CITY OF ALBUQUERQUE

August 8, 2025

Re: Panda Express
2040 Gibson Blvd SE
30-Day Temporary Certificate of Occupancy
Transportation Development Final Inspection
Engineer's Stamp dated 06-10-24 (M15-D021F)
Certification dated 07-31-2025
TRANS-2025-00213

MOTORCYCLE PARKING
SIGN DETAIL

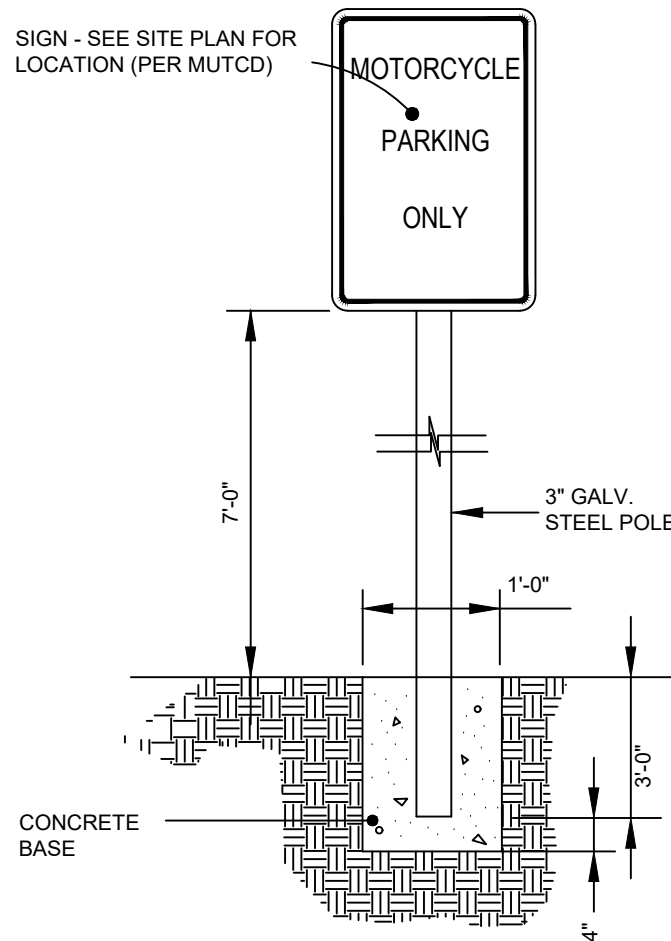
- Keynote 23: Per approved site plan "STOP" sign must be provided at the exit of the drive through lane.
- Per approved site plan, Motorcycle sign and "MC" pavement marking must be provided.
